Our Ref: R/2017/14/P
File No: SSD 8517 Mod 9

**Section 4.55(1A) Modification Application
Bays 1-4A, Locomotive Workshops, South Eveleigh – SSD 8517
Modification 9 Add Blacksmith Flues**

4 PROPOSED - LONG SECTION B - RETAIL
1 : 250

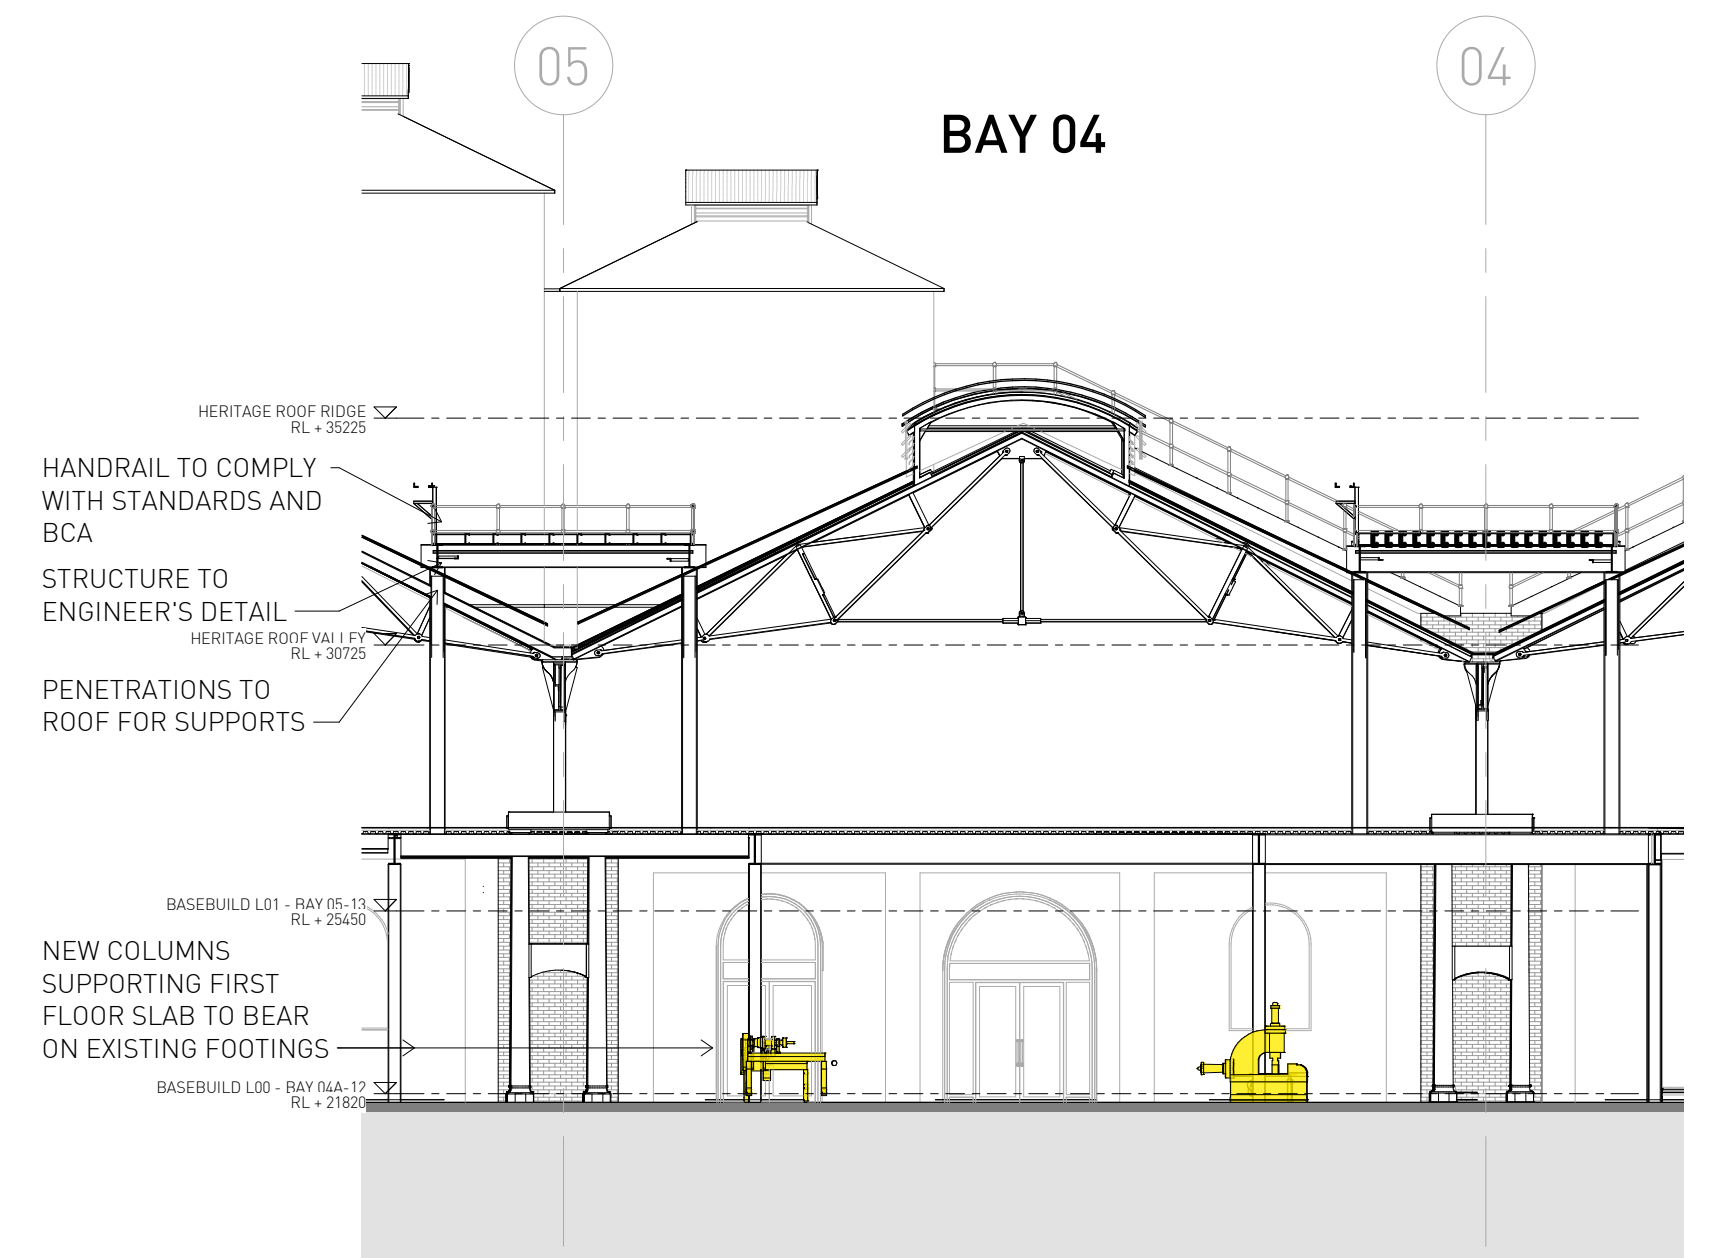
1. The Mechanical Ventilation design which is claimed to be more efficient at capturing direct exhaust emissions and smoke generated during furnace and oil quenching operations, to ensure future staff are protected. All mechanical ventilation should be compliant with AS1668 and signed off by a competent person (e.g. mechanical engineer or similar) prior to the issue of a Construction Certificate.
2. Confirm if the applicant will utilise a cleaner fuel source such as LPG gas. If so, further assessment of air quality should be conducted following any ventilation or fuel source upgrades to confirm that changes have not adversely affected air conditions; if the information cannot be provided this should form part of the consent conditions.

6 FURNACE FLUES DETAIL SECTION
1 : 150

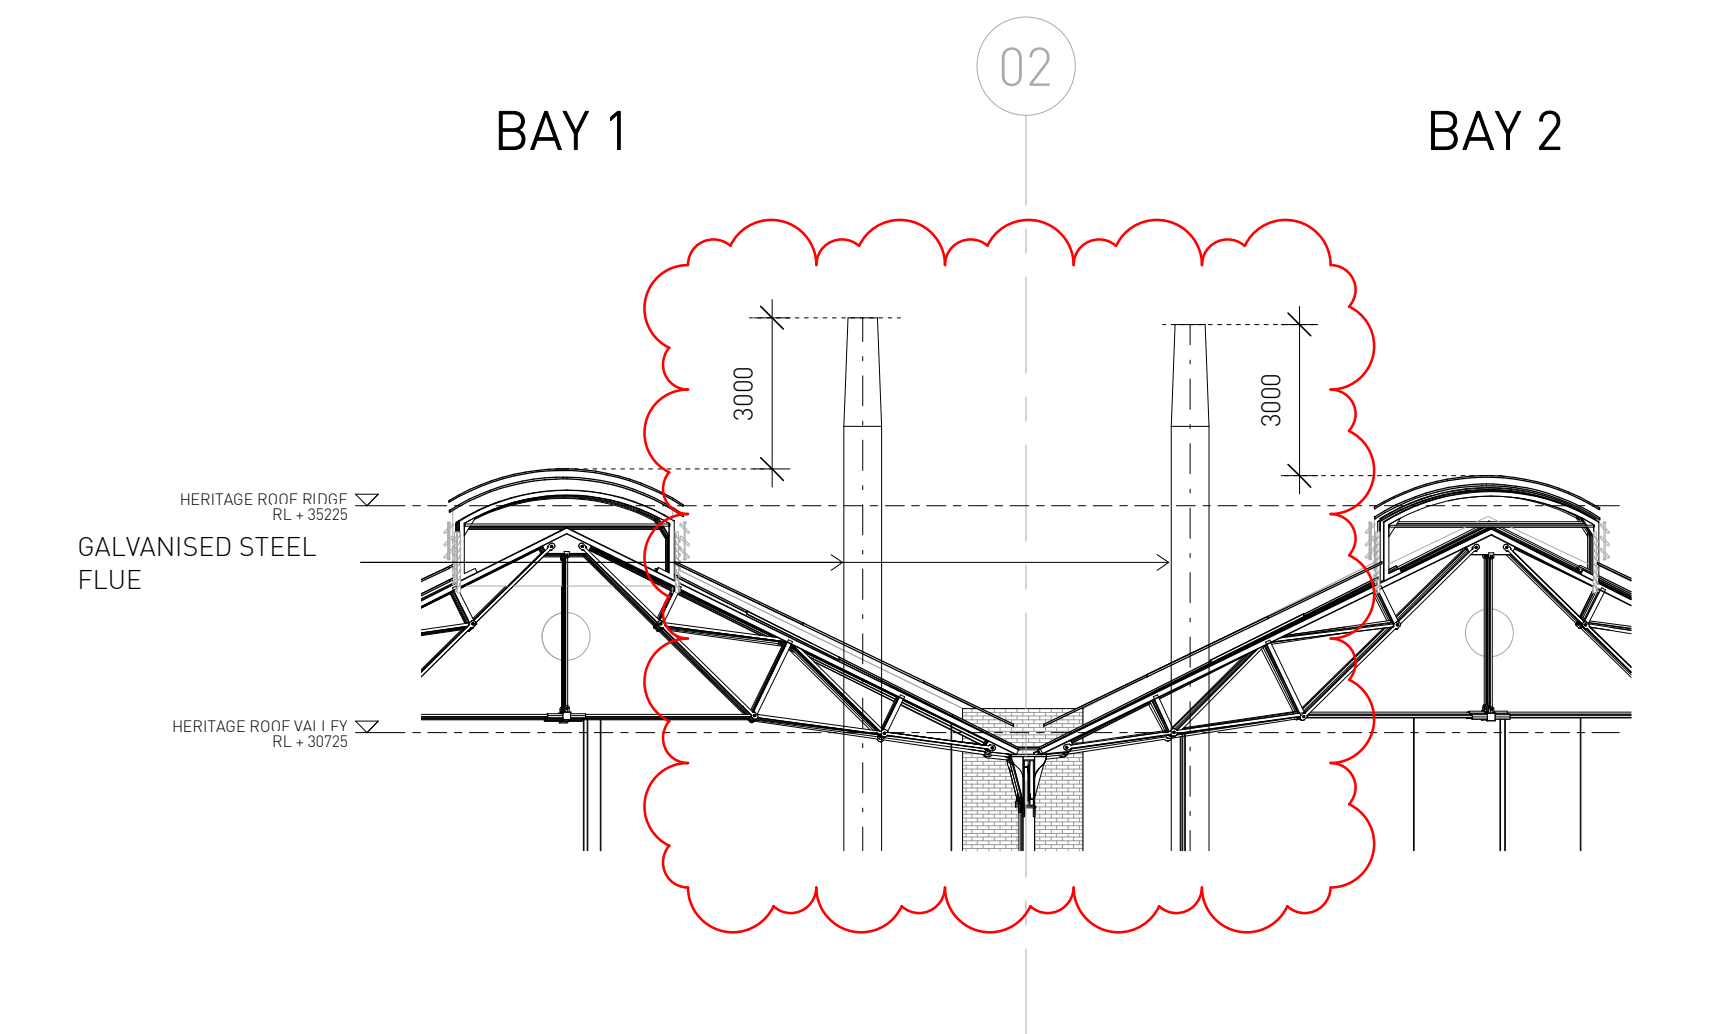
From a heritage perspective the proposed flues have galvanised steel finish and appear to be supported from the existing trusses by cables. This is all considered reversible and can be supported as they fit in with the industrial context of the site.
